December 21, 2020

Re: Project Name: 8815 Hot Mix Heights Development Plan 2020

Letter of Intent_v1.pdf Markup Summary

JOB NUMBER	965-20
REVISIONS	
ORIGINAL DATE	12-22-20
DRAWN BY	JM
DESCRIPTION	LANDSCAPE PLAN
SHEET NO.	L1.1

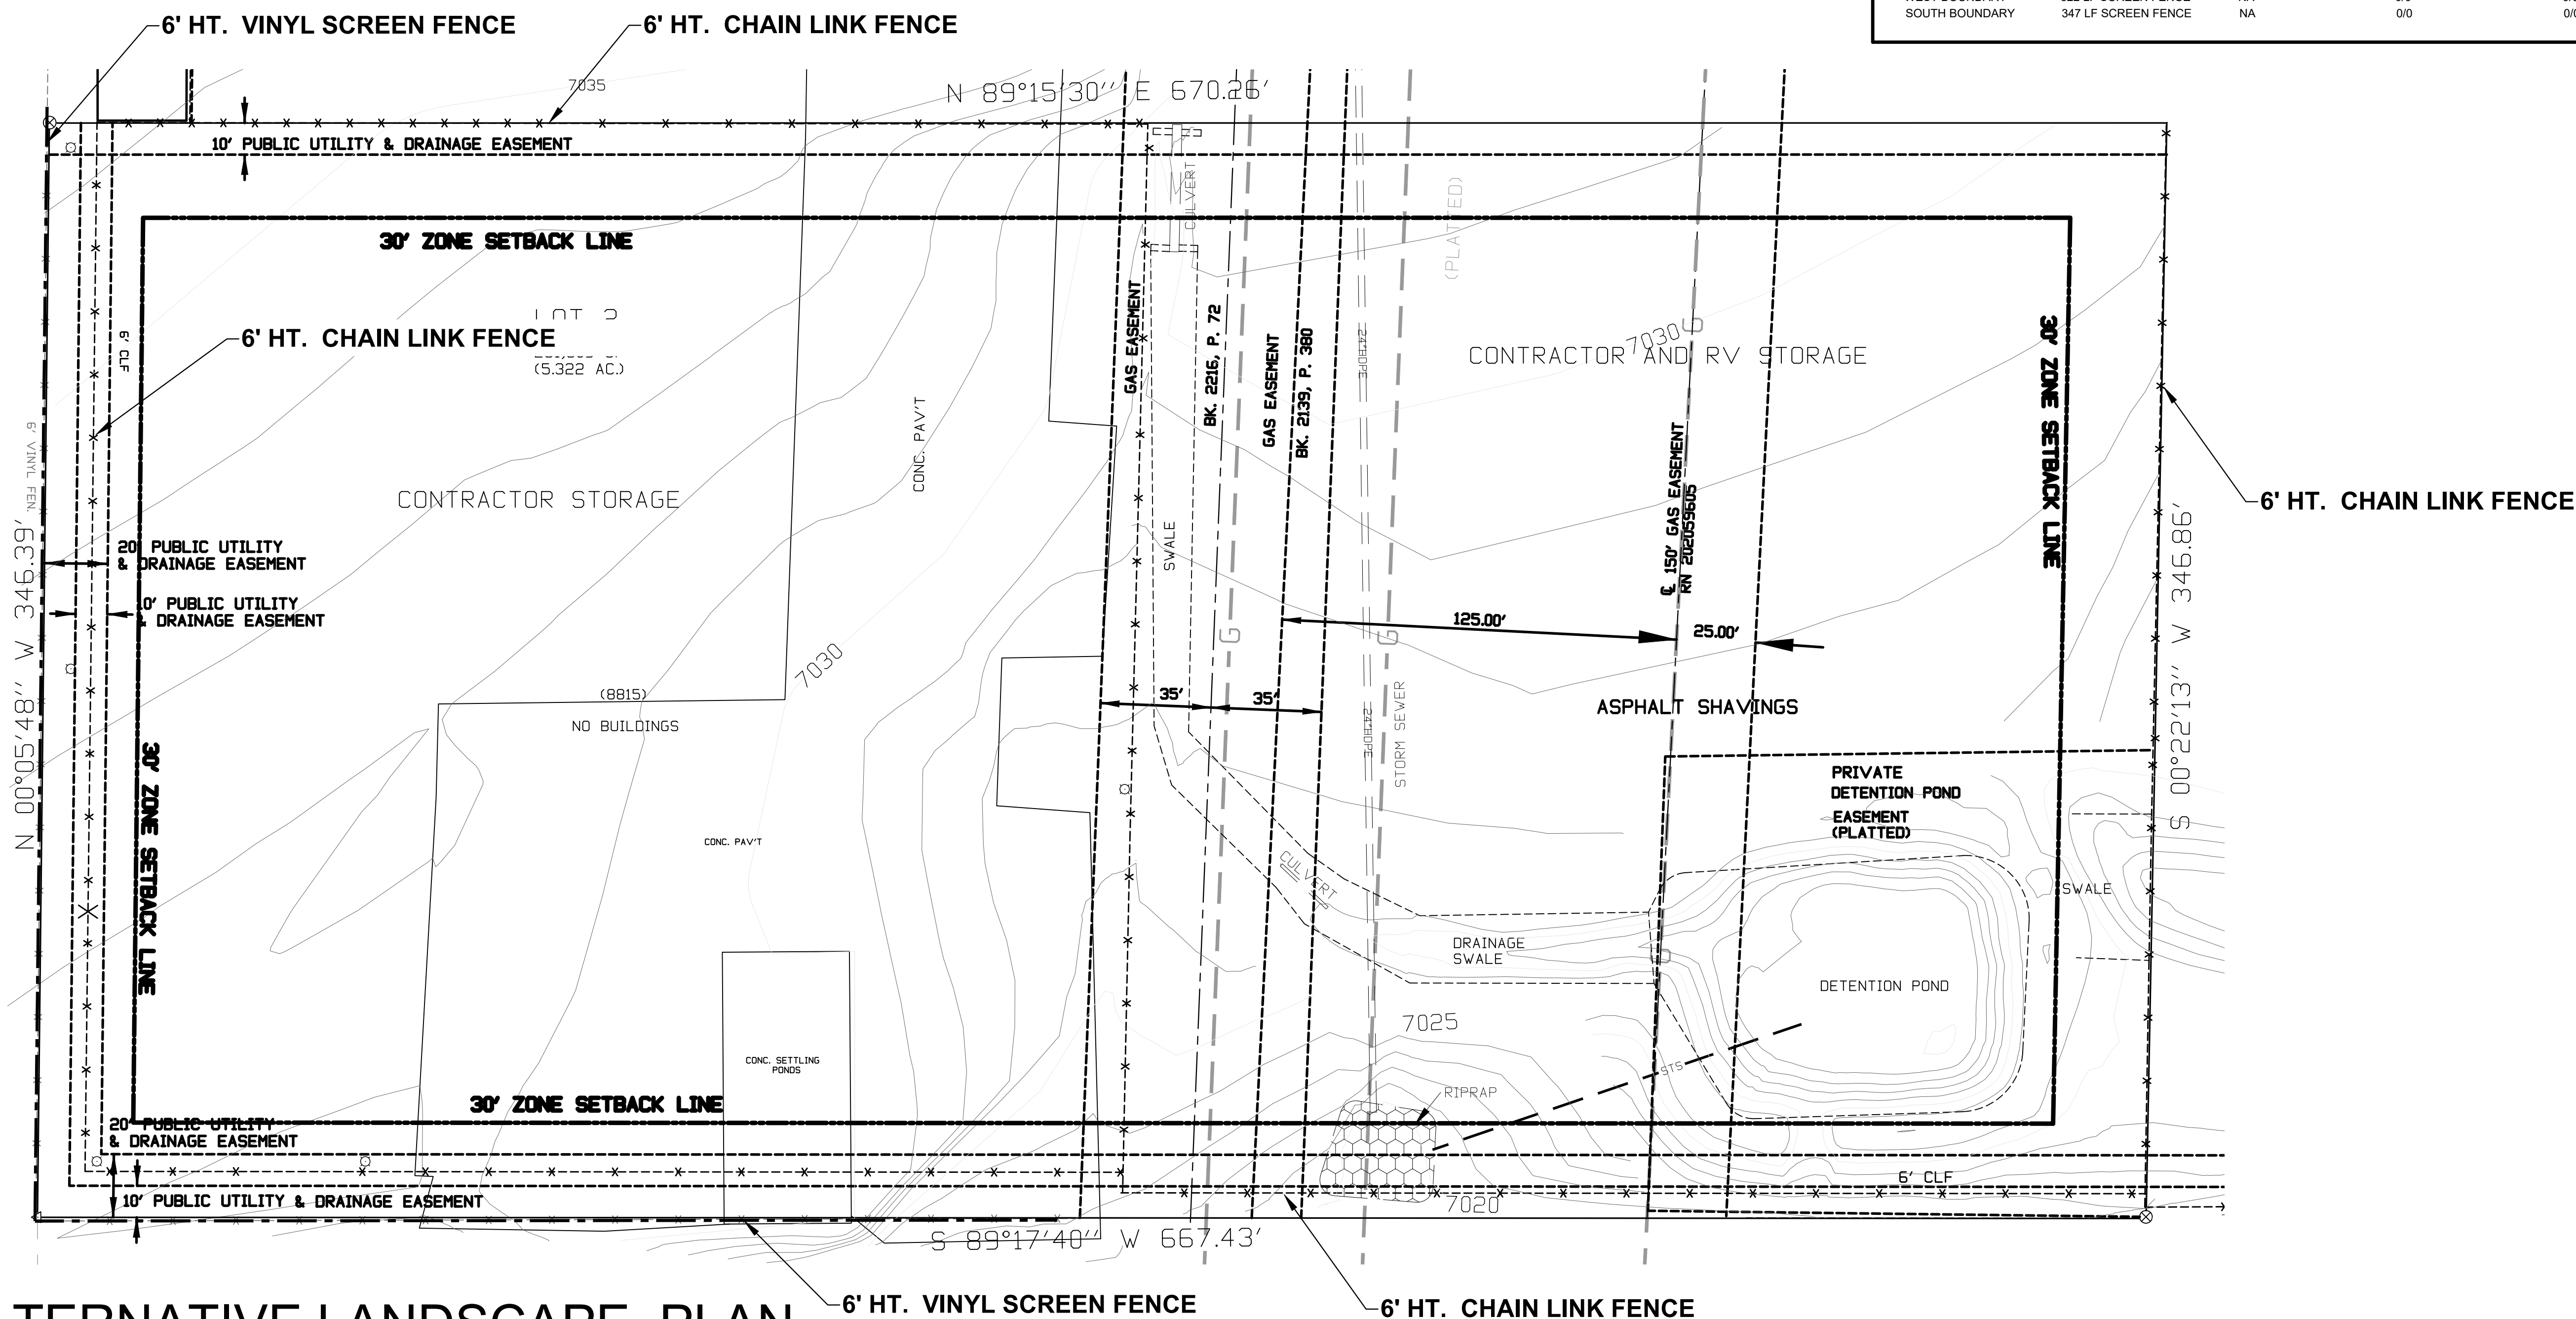
Please note that the landscaping standards required per Chapter 6 for all land uses are different from the intent/requirements of landscape buffering standards for adjacent uses (for outdoor storage requirements per Ch.5). Please justify how the alternative landscaping proposed meets the purpose of the code and promotes the concepts contained in the Landscape and Water Conservation Manual.

Please also add this justification information for alternative landscape plan in your letter of intent.
